Case Officer: Katherine Daniels

Applicant: Great Lakes UK Limited

Proposal: 1. Introduction of ventilation grilles above all guestroom windows;
2. Reduction of brick plinth to back of house areas of waterpark building;
3. Change of rear of hotel from stone to render retaining stone surrounds and sills; 4. Change of rear of hotel from stone to timber with timber surrounds and metal sills; 5. Change from stone plinth to buff brick plinth to back of house areas of waterpark building; 6. Change of buff brick from blue brick material around plinths; 7. Reduction of extent of plant screening above conference zone where plant is no longer present; 8. Reposition slow windows to eaves to raise them slightly; and, 9. Re-align windows above porte cochere (proposed as non-material amendment to 21/04158/F)

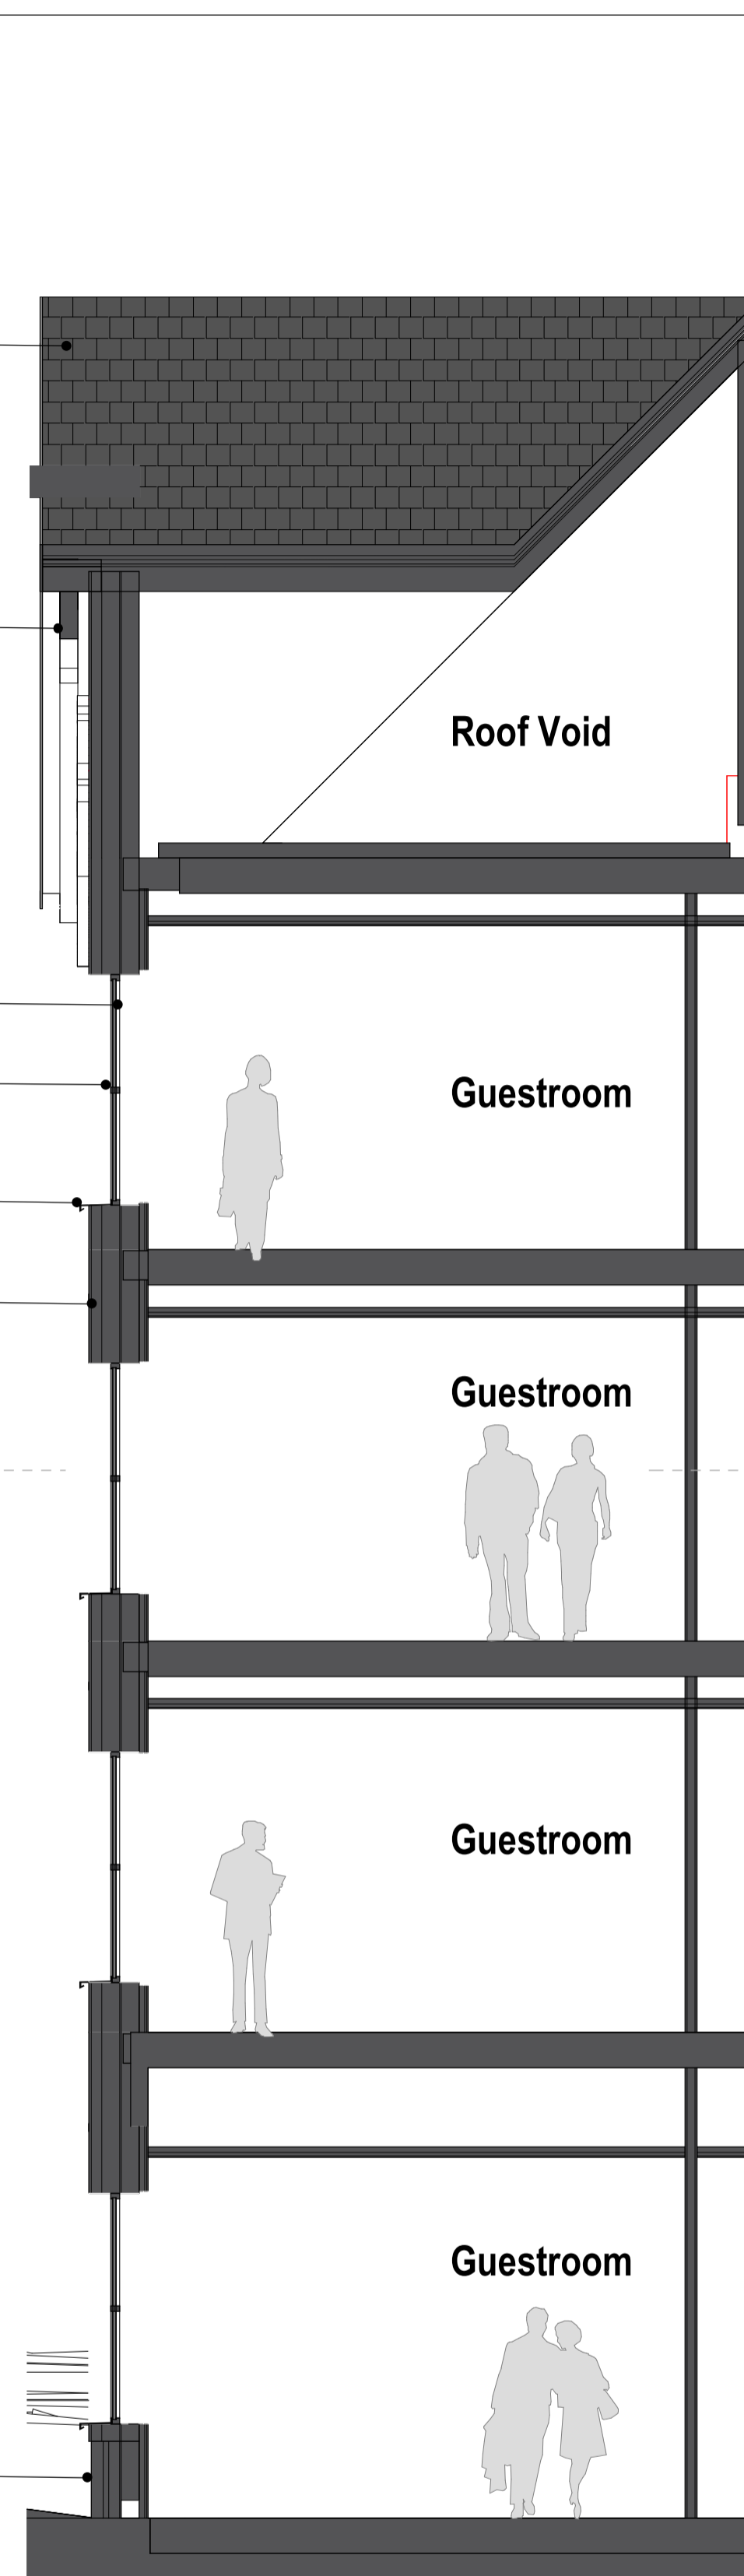
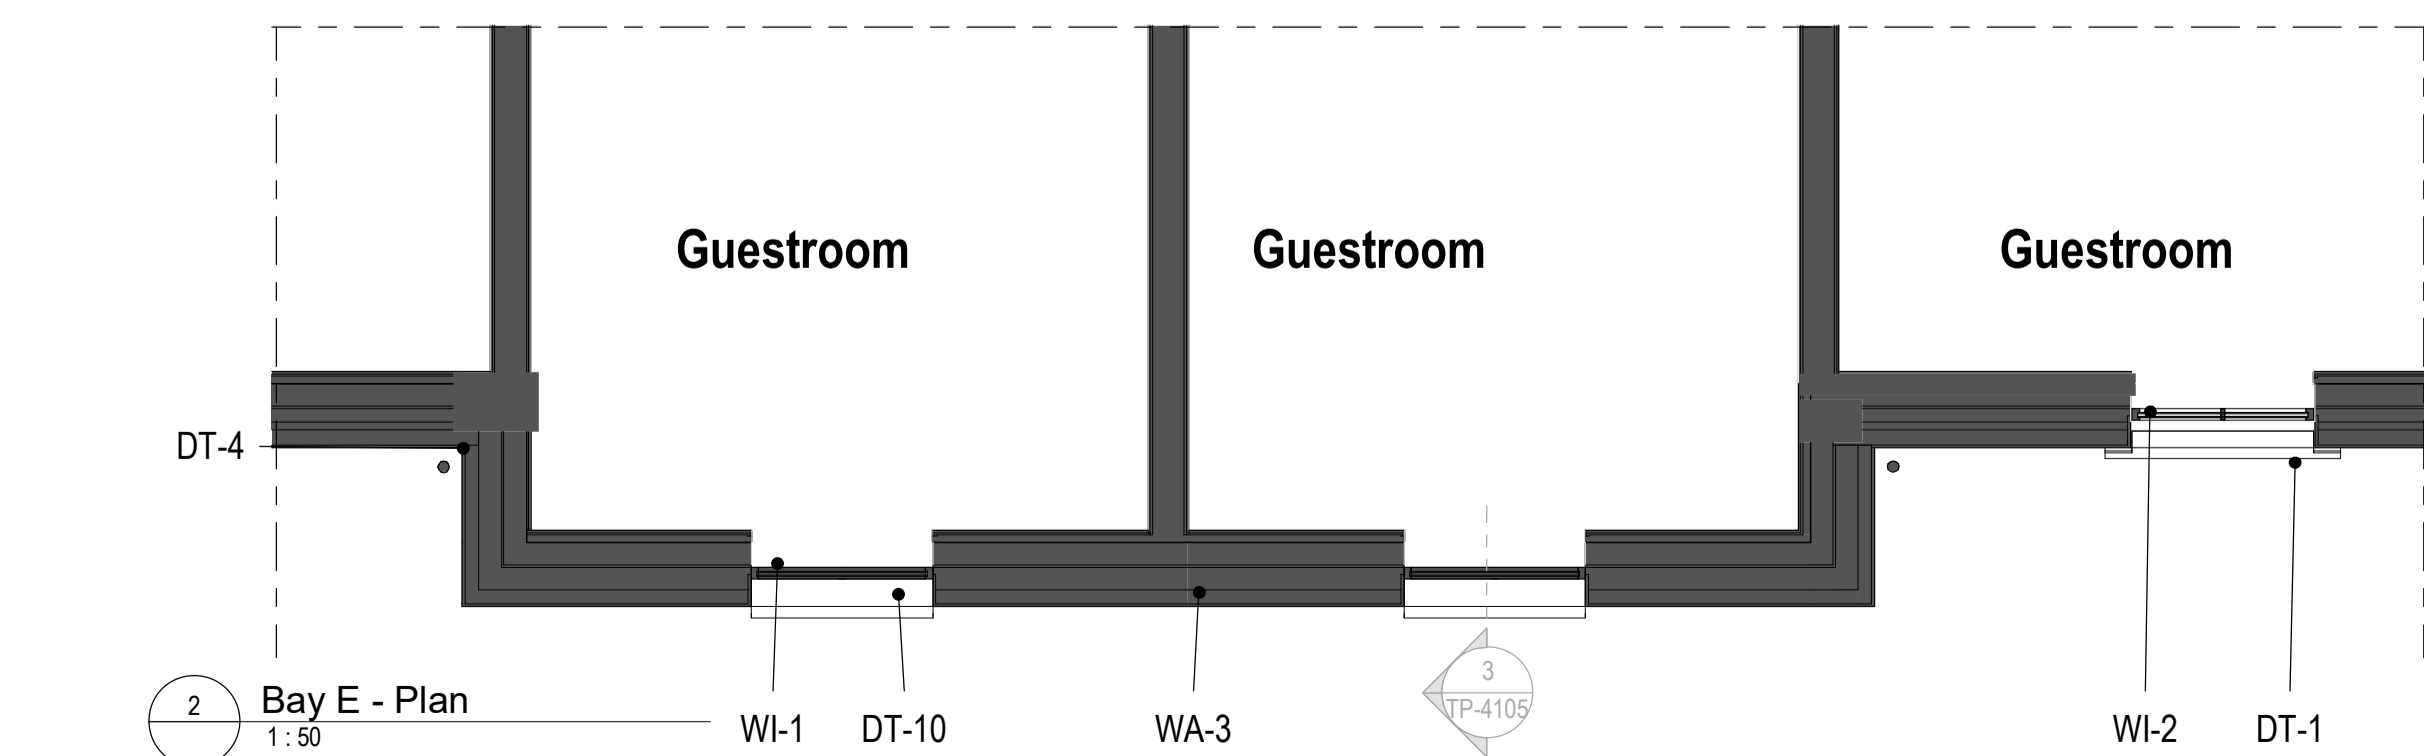
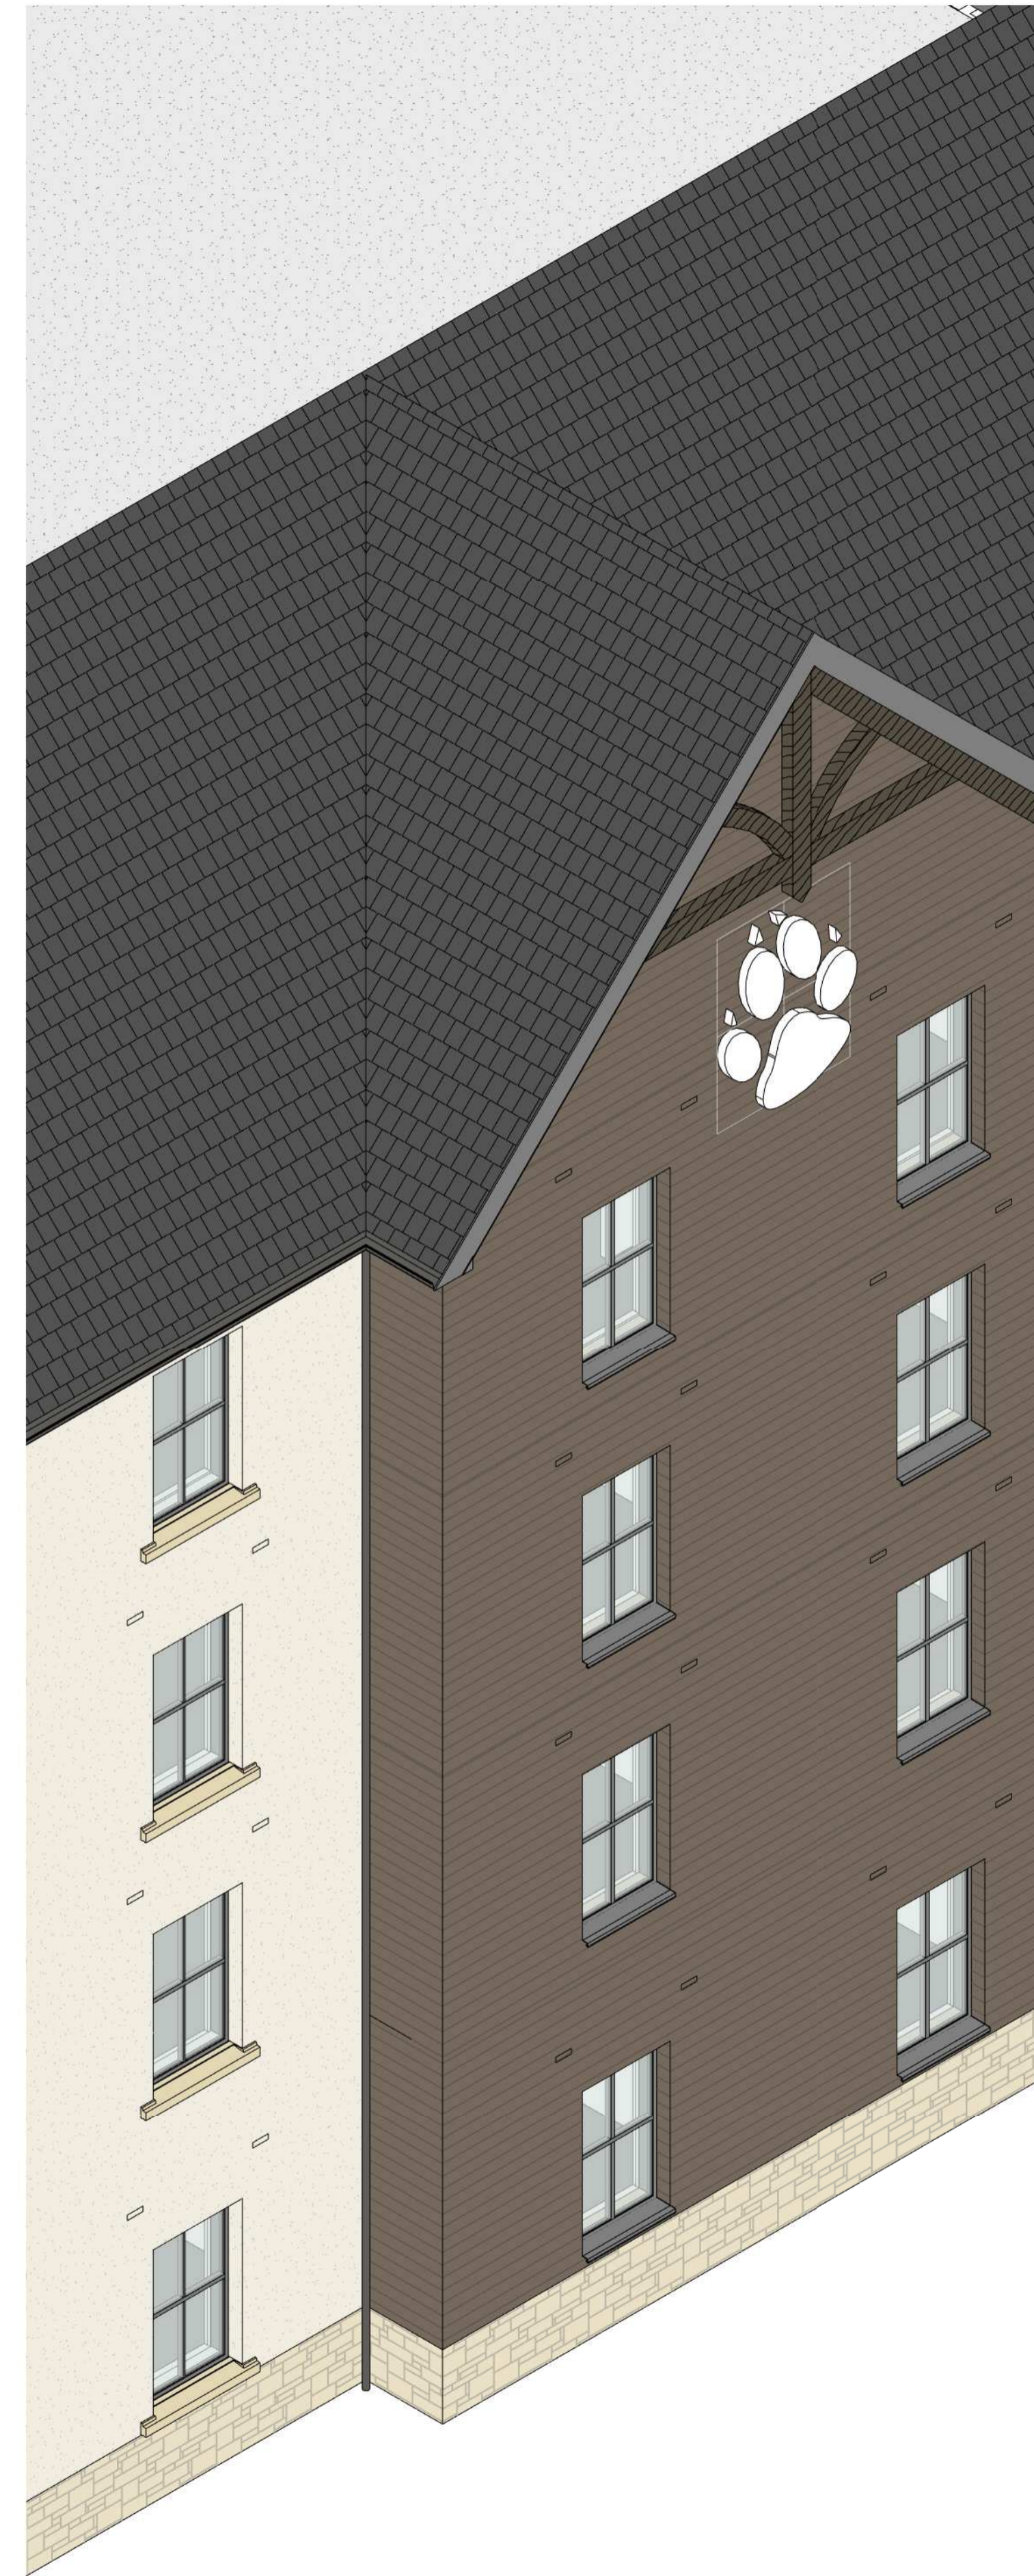
- 5.5. The introduction of ventilation grilles above the guestrooms is a change to the overall appearance of the building, however given the size of these grilles and the massing of the proposed building, it is unlikely to result in a material change to the overall character of the building. The character of the building will still remain.

- 5.10. The reduction of plant screening, is considered to be acceptable, and will not alter the overall development as a whole.
- 5.11. The reposition of the slow windows to eaves and raise them slightly again does not alter the overall design and appearance of the original scheme. The changes to these are minimal.
- 5.12. The windows are due to be re-aligned above the porte cochere changes are considered to be acceptable and does not affect the overall character and appearance of the building.
- 5.13. It is considered that some of the changes are unfortunate, however, overall, it is considered that the proposed alterations, given the overall size of the development will not alter the character and appearance of the proposed development. The alterations are considered to be non-material.
